OUR REF: 476088 - 01000

Re: **1354 Carling Avenue CTS/TIS**
Addendum #1

The Community Transportation Study/Transportation Impact Study (CTS/TIS) for the proposed residential development located at 1354 Carling Avenue was submitted in April 2017. Comments have been received on the CTS/TIS from the City of Ottawa and the Site Plan for Phases 1 and 2 has been revised and is attached (Attachment #1). This Addendum #1 has been prepared to address the comments received and address the transportation related changes to the proposed Site Plan, which include:

476217 Dwg. No. 001
 Sheet 1 of 3

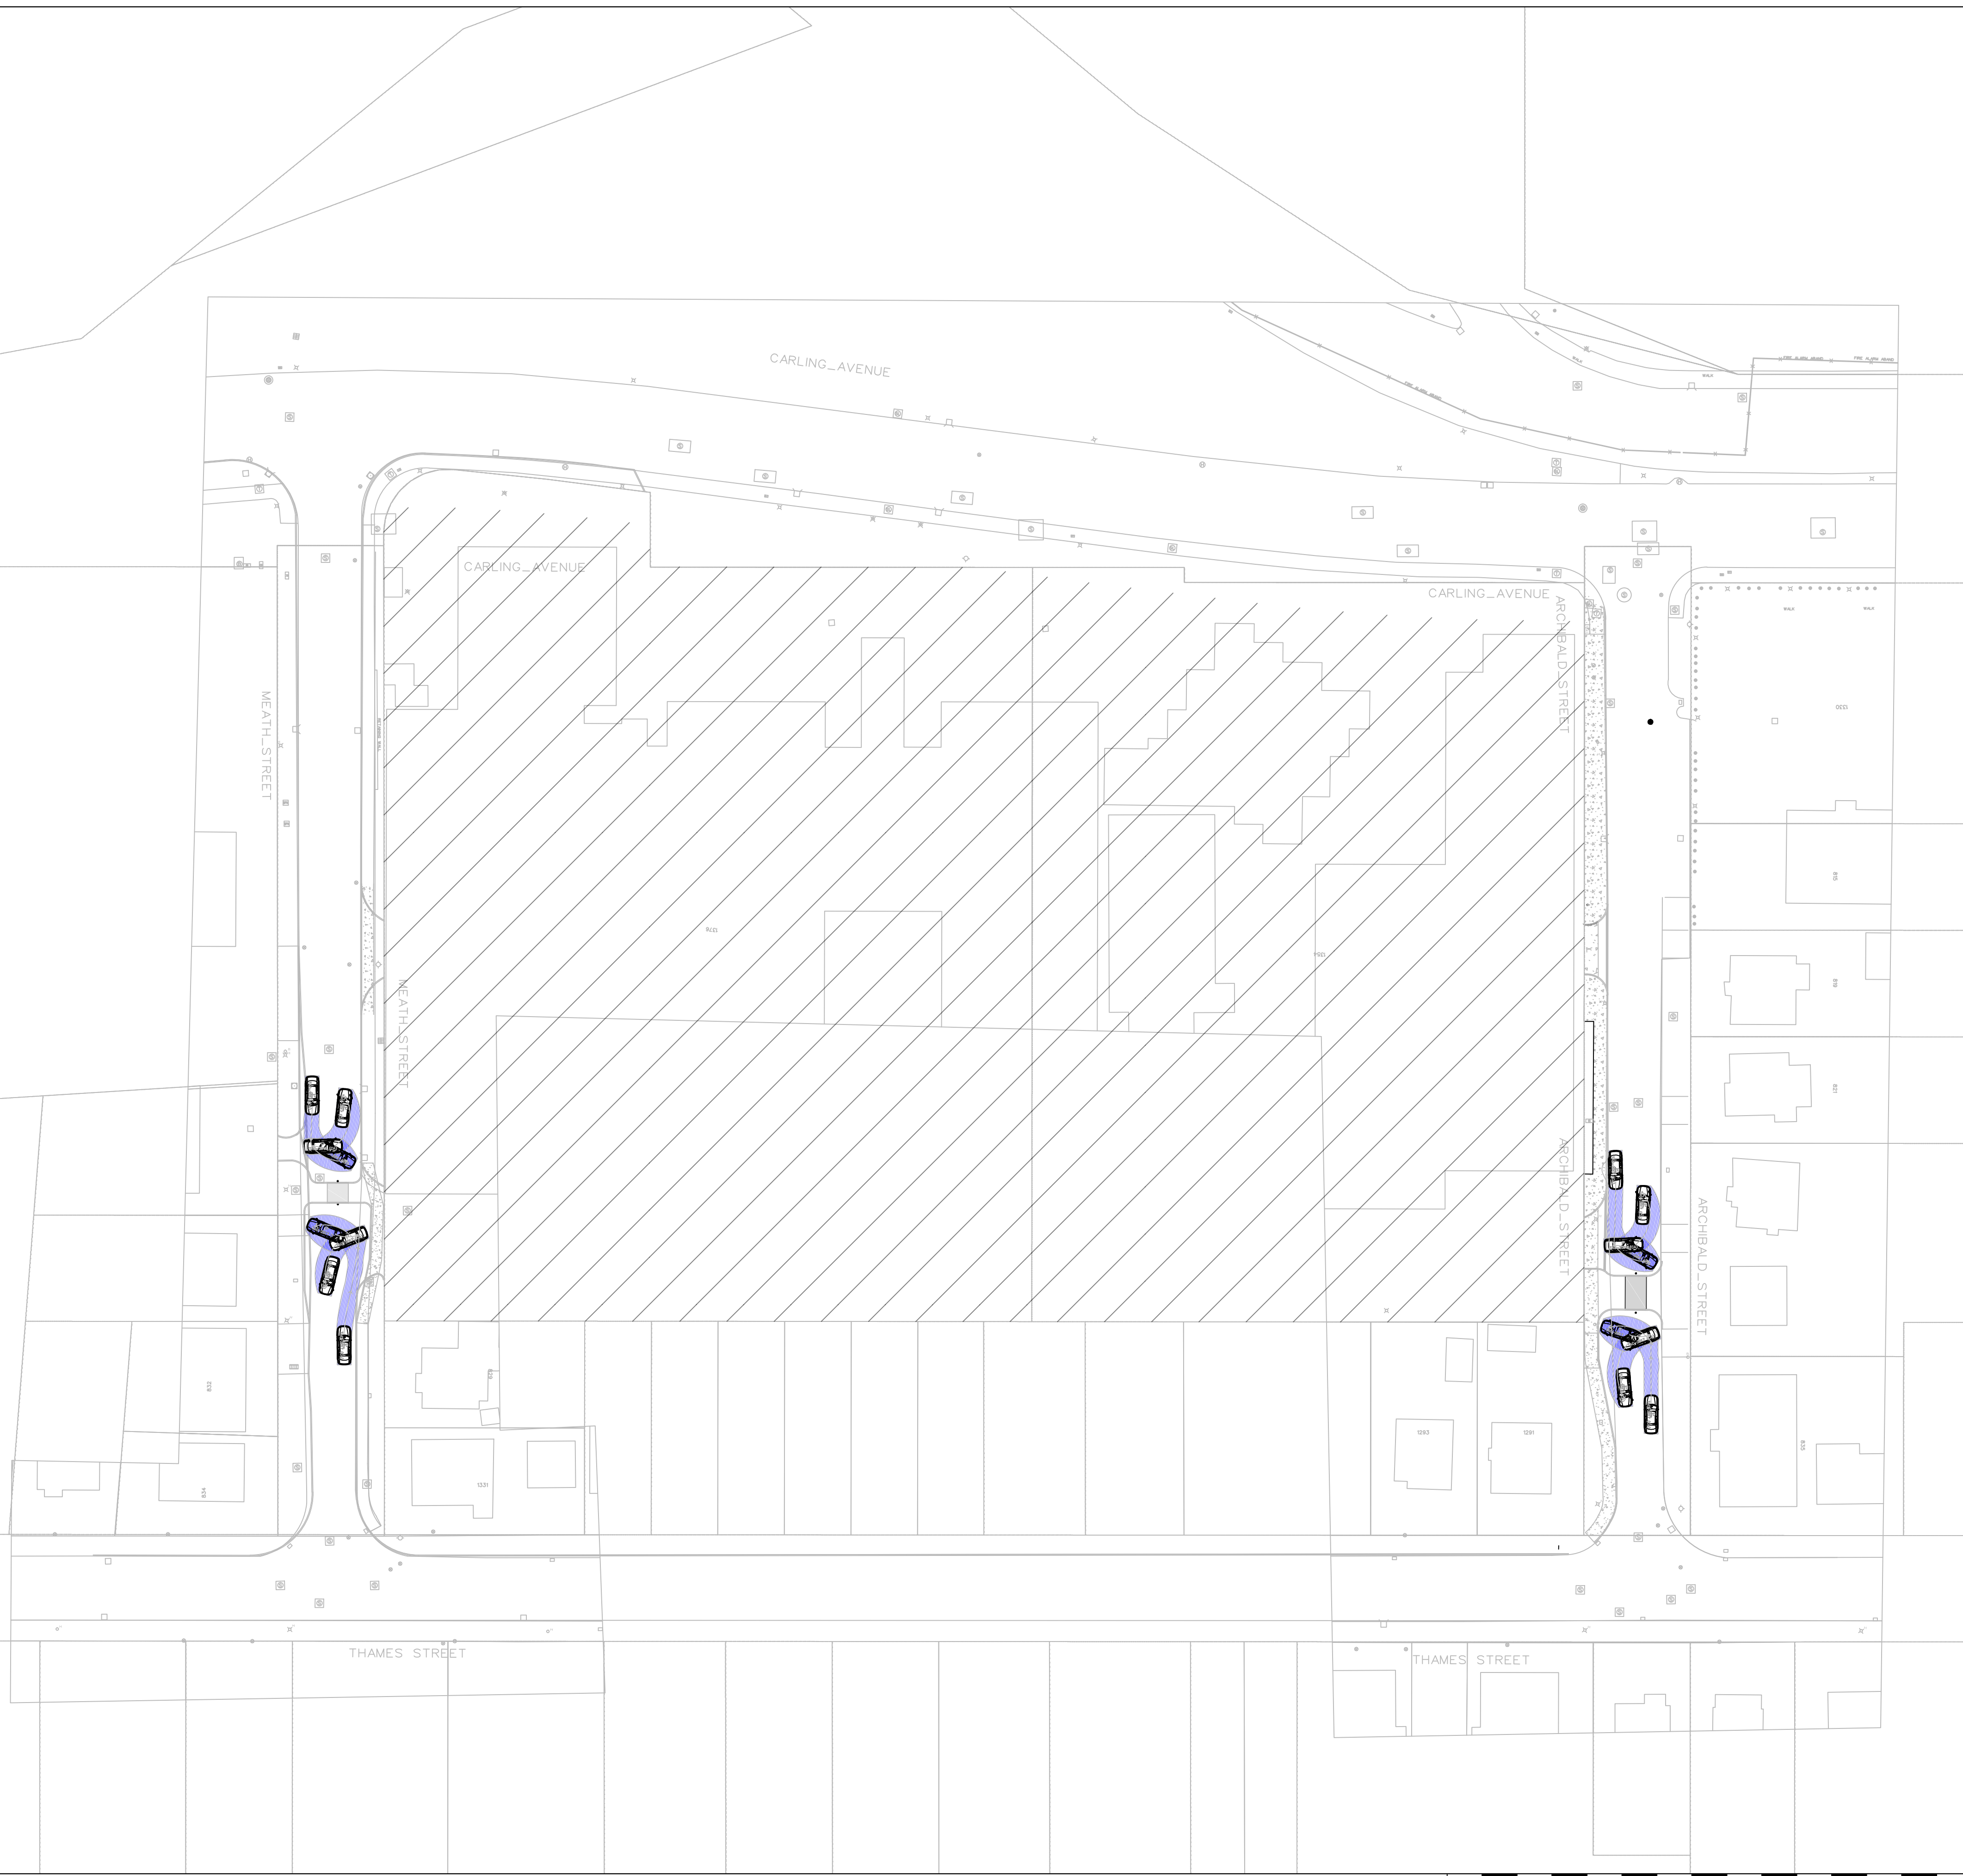
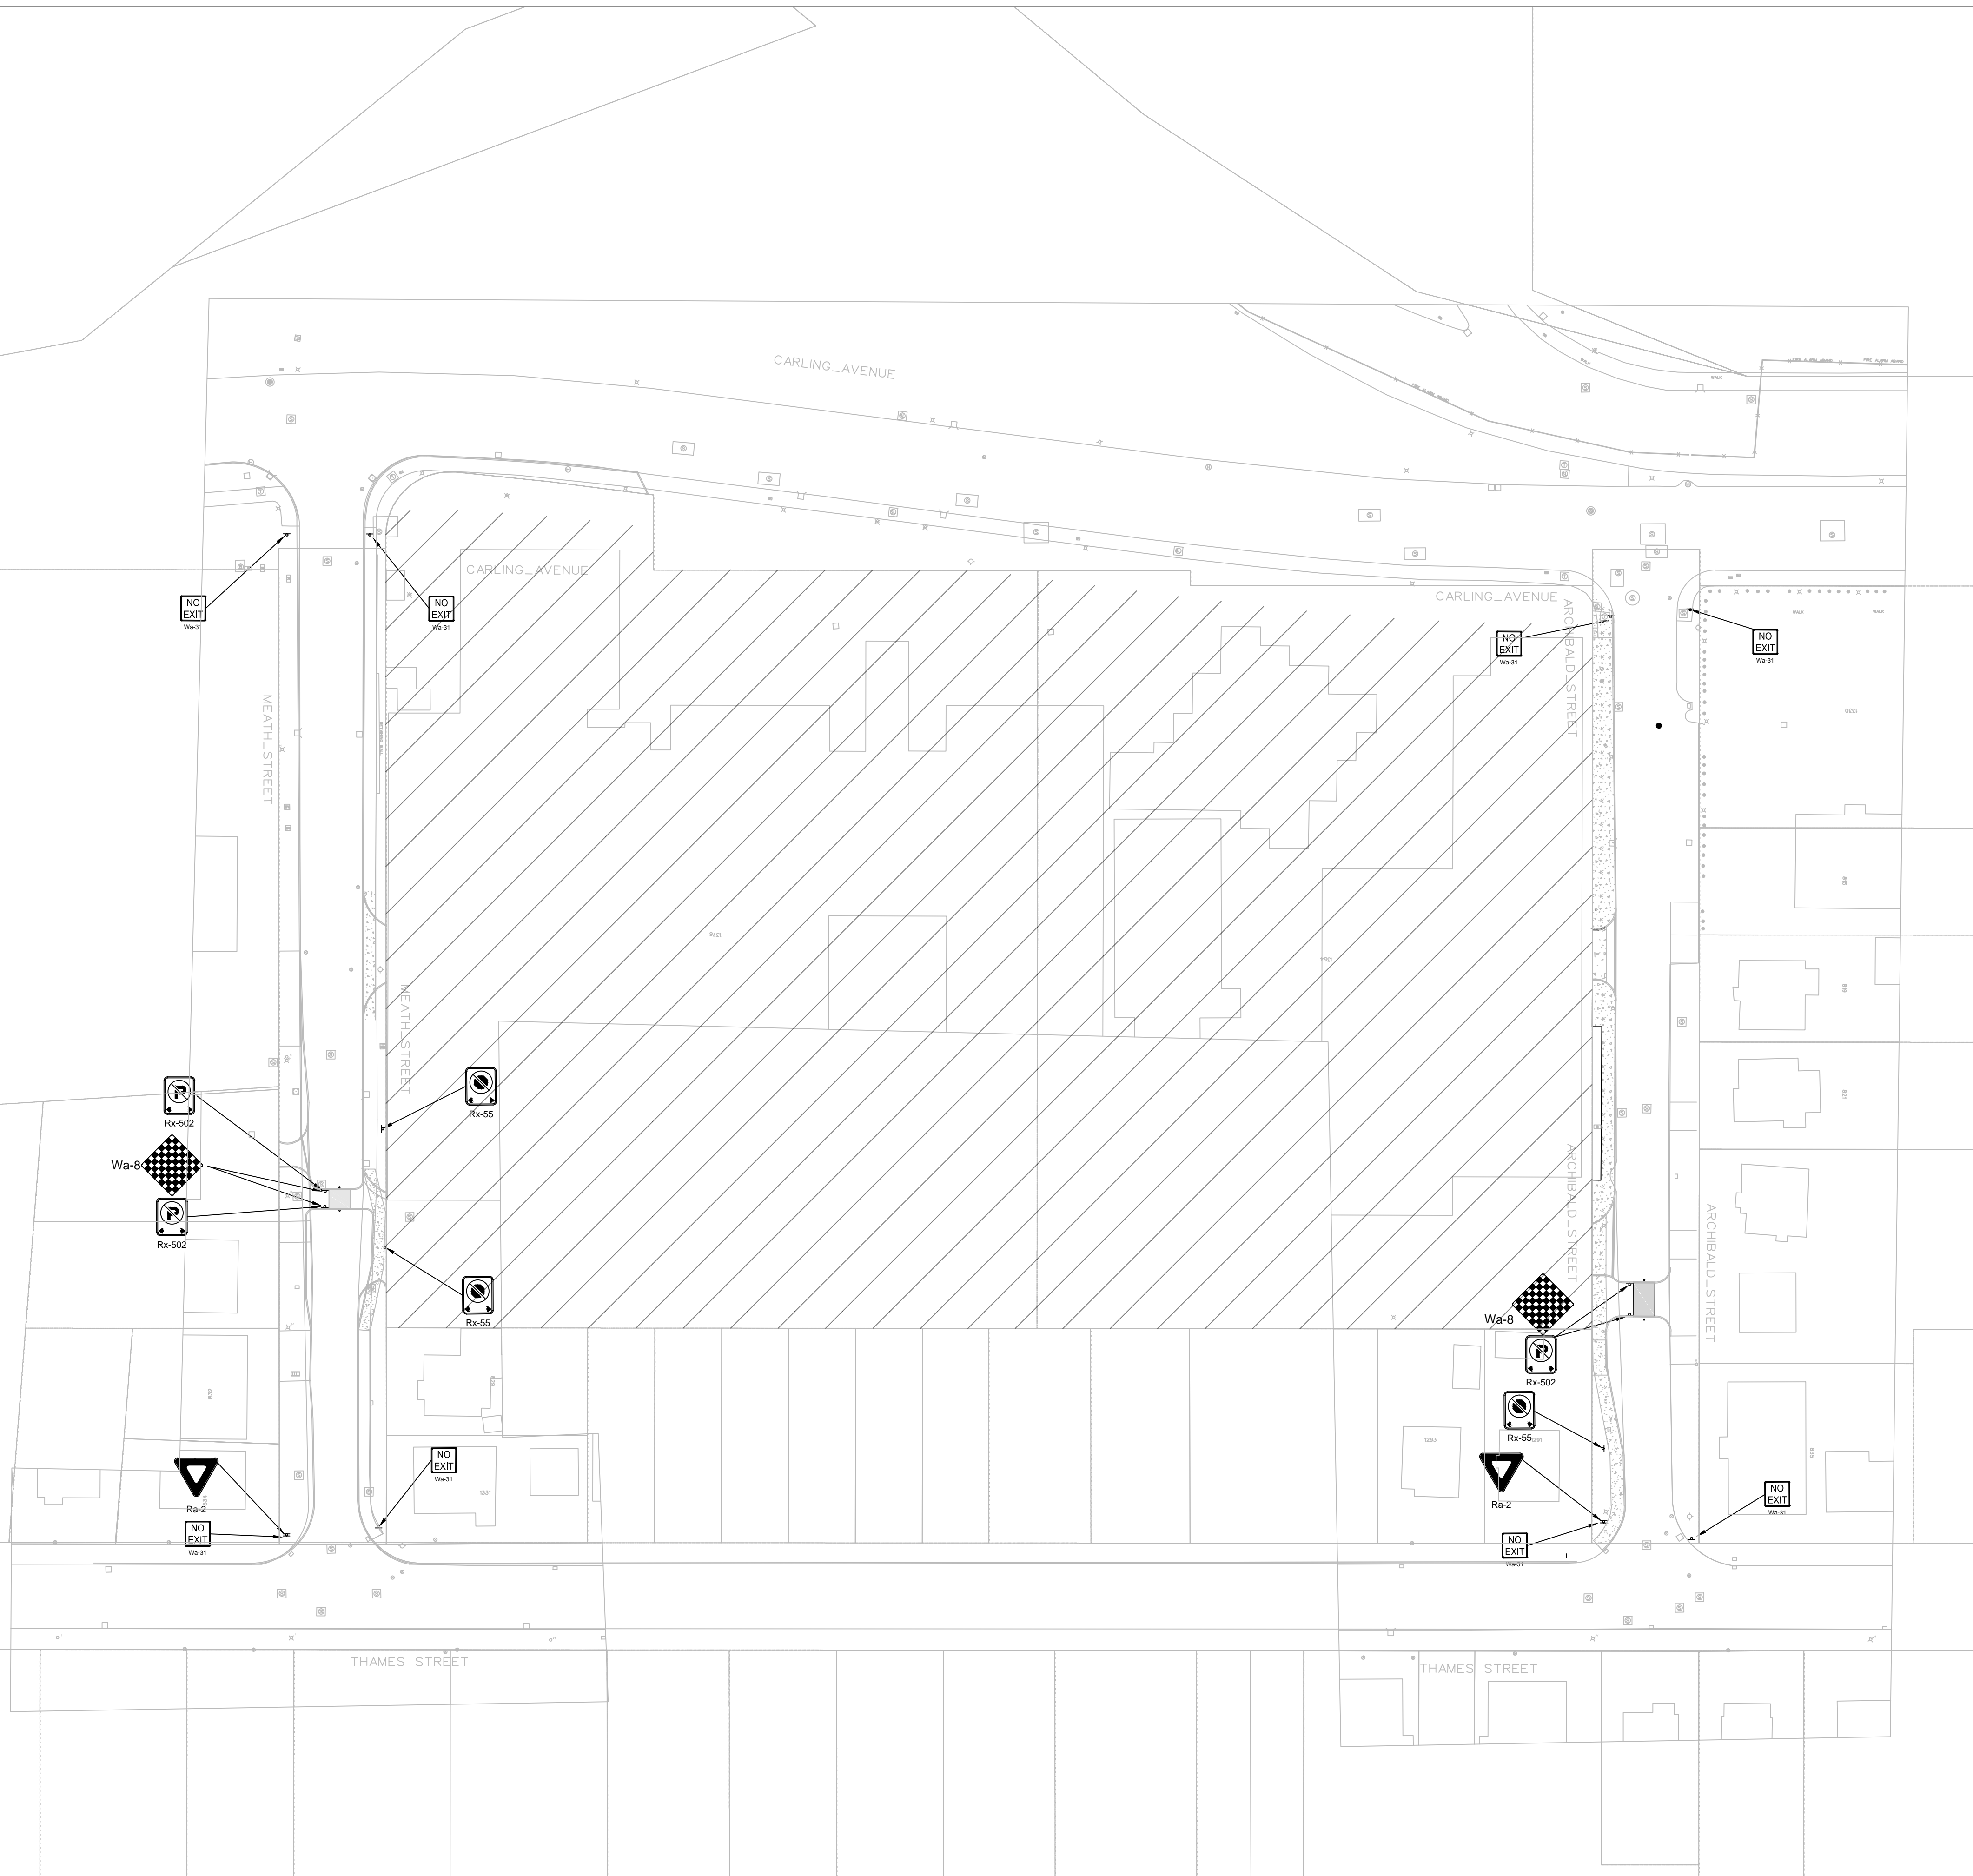
Comment 2.22: *Modifications to Meath Street and Archibald Street may be required to control movements from the site. Provide a road plan showing the location of the existing accesses on both sides of these streets.*

Response 2.22: The options for improvements to the bulb outs on Archibald Street and Meath Street were also assessed as part of the Technical Memorandum prepared in March. The following Figure 4 shows a proposed options to help enforce the one-way operation of Meath Street and Archibald Street at their intersections with Thames Street. As shown there are private driveways just north of each of the proposed bulb-outs.

1354-1376
CARLING AVE
CONCEPT SITE PLAN

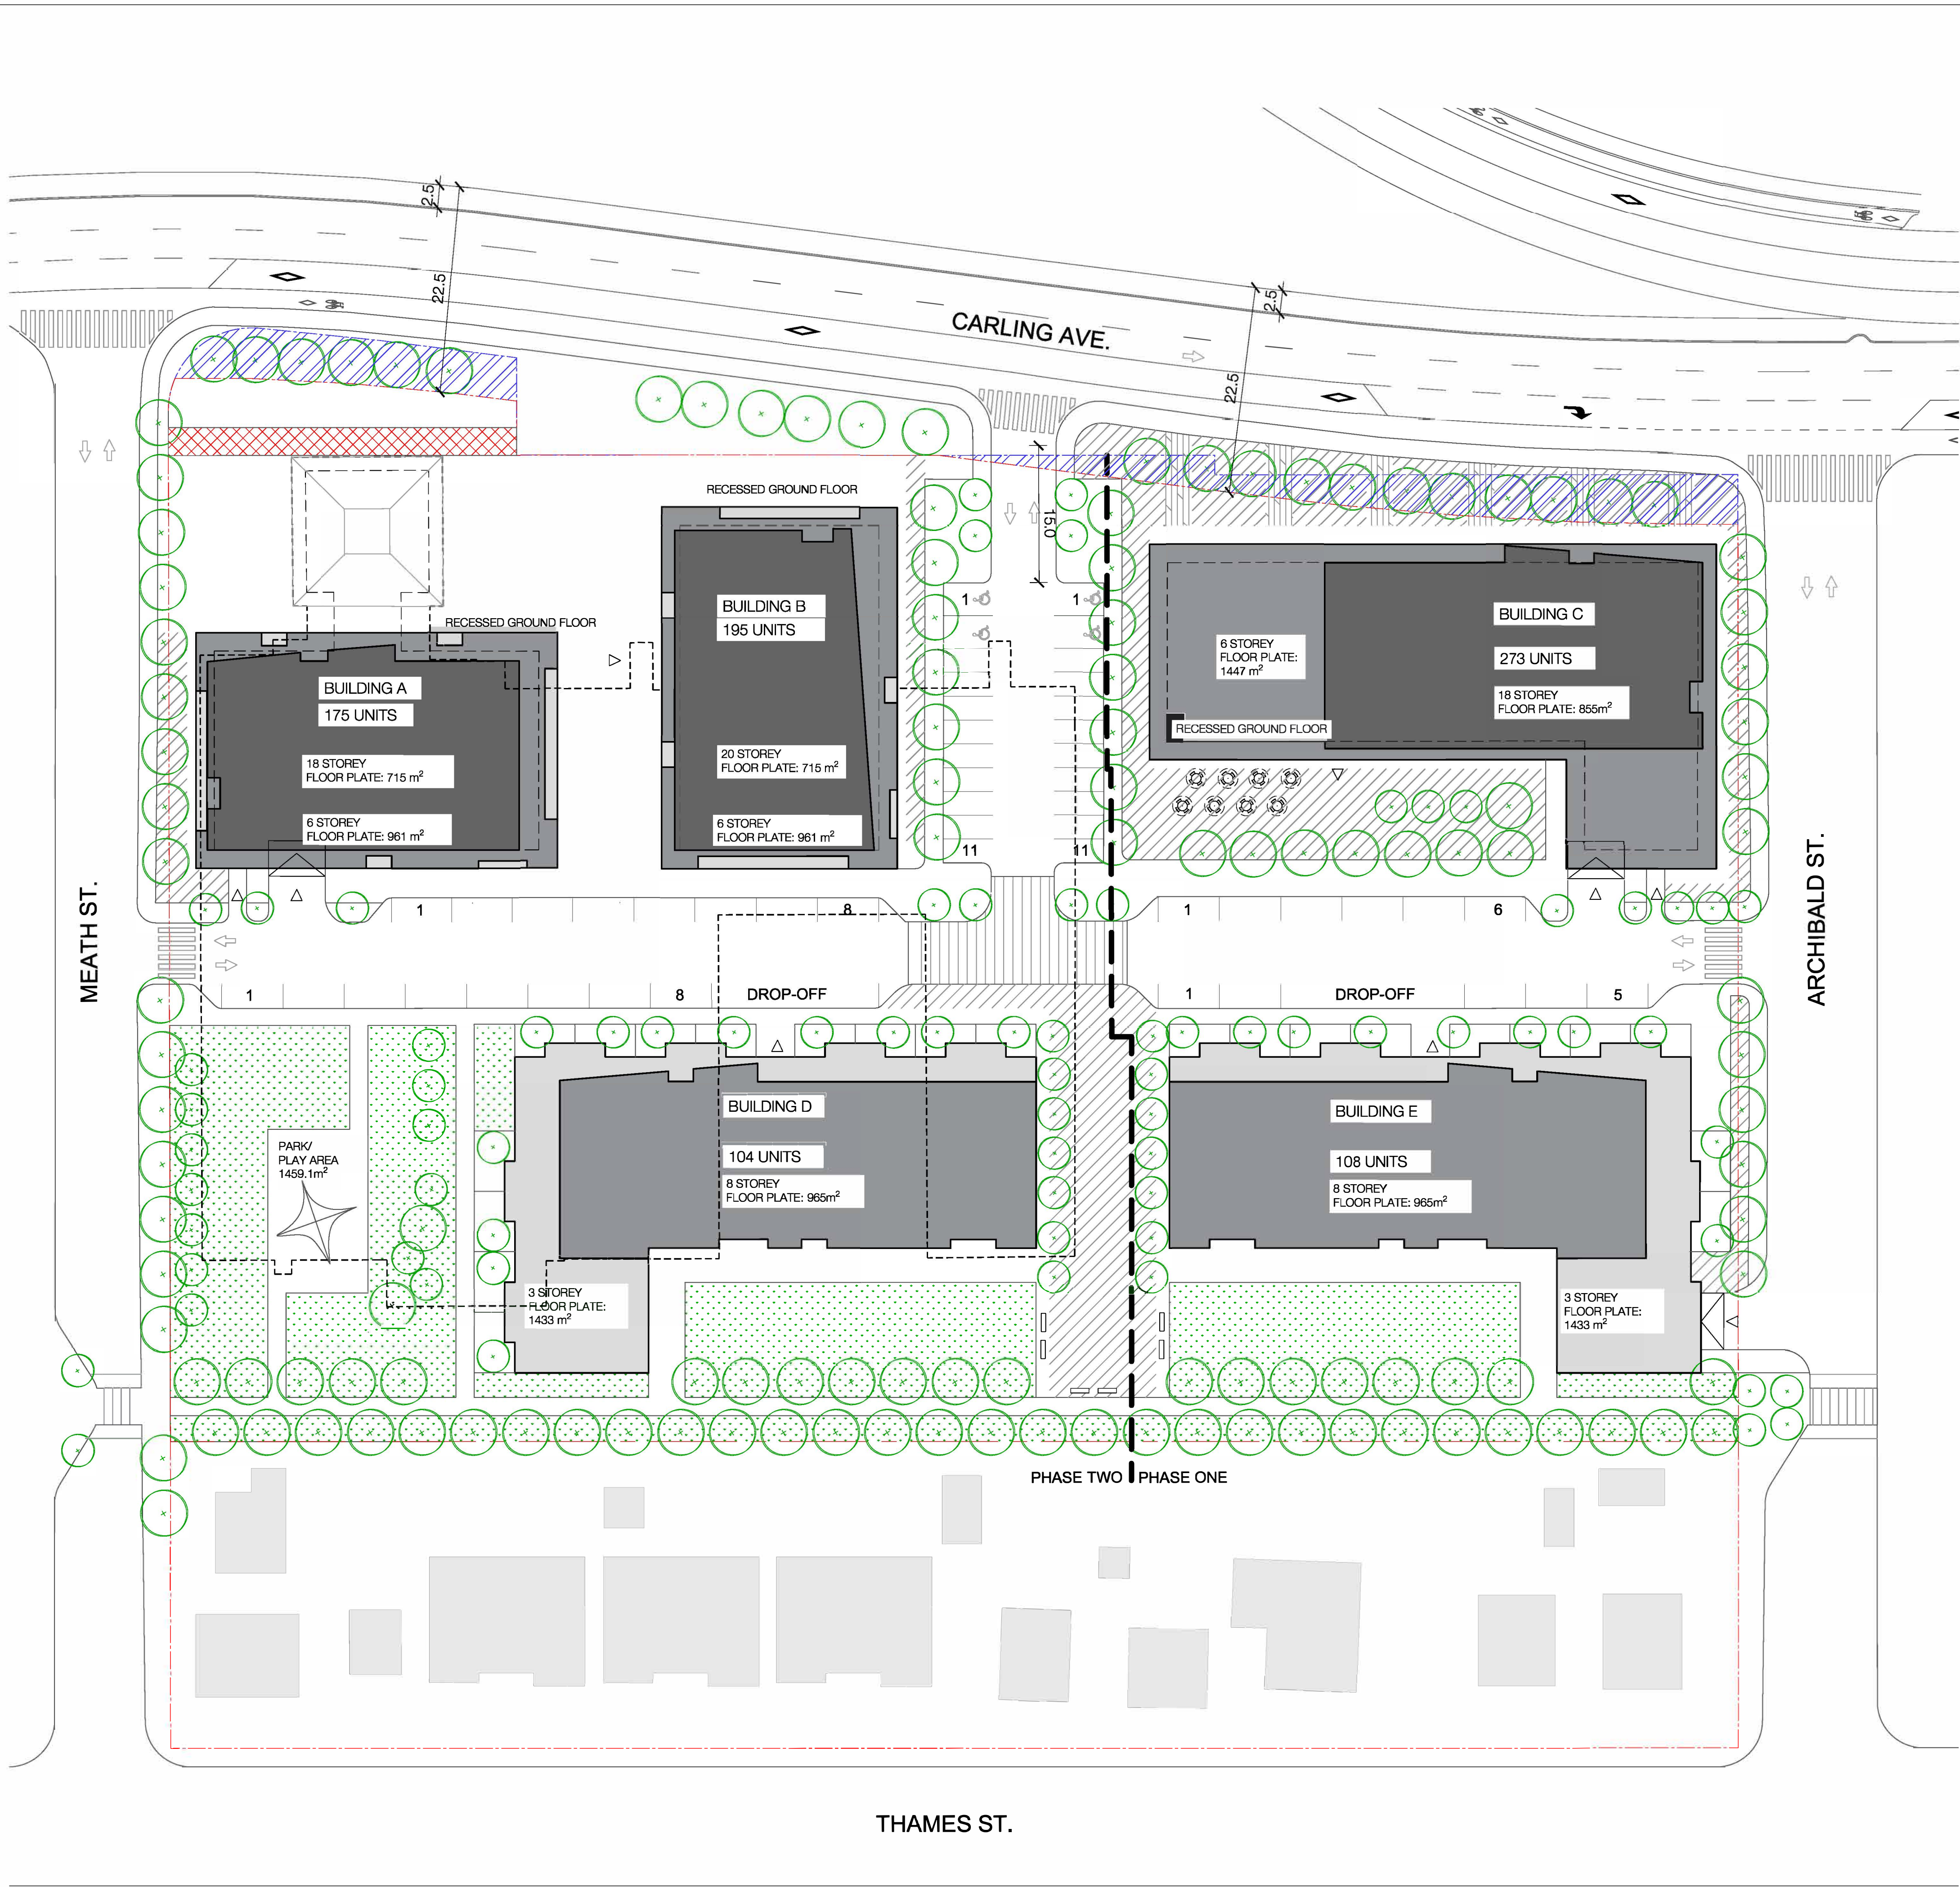
Comment 2.27: *Please refer to TAC Manual Part 2; Table 3.2.9.3 and Figure 3.2.5.2 for appropriate throat length and dimensioning.*

Response 2.27: The throat length for the proposed Carling Avenue driveway connection has been redesigned and is included in the updated Phase 2 Site Plan.
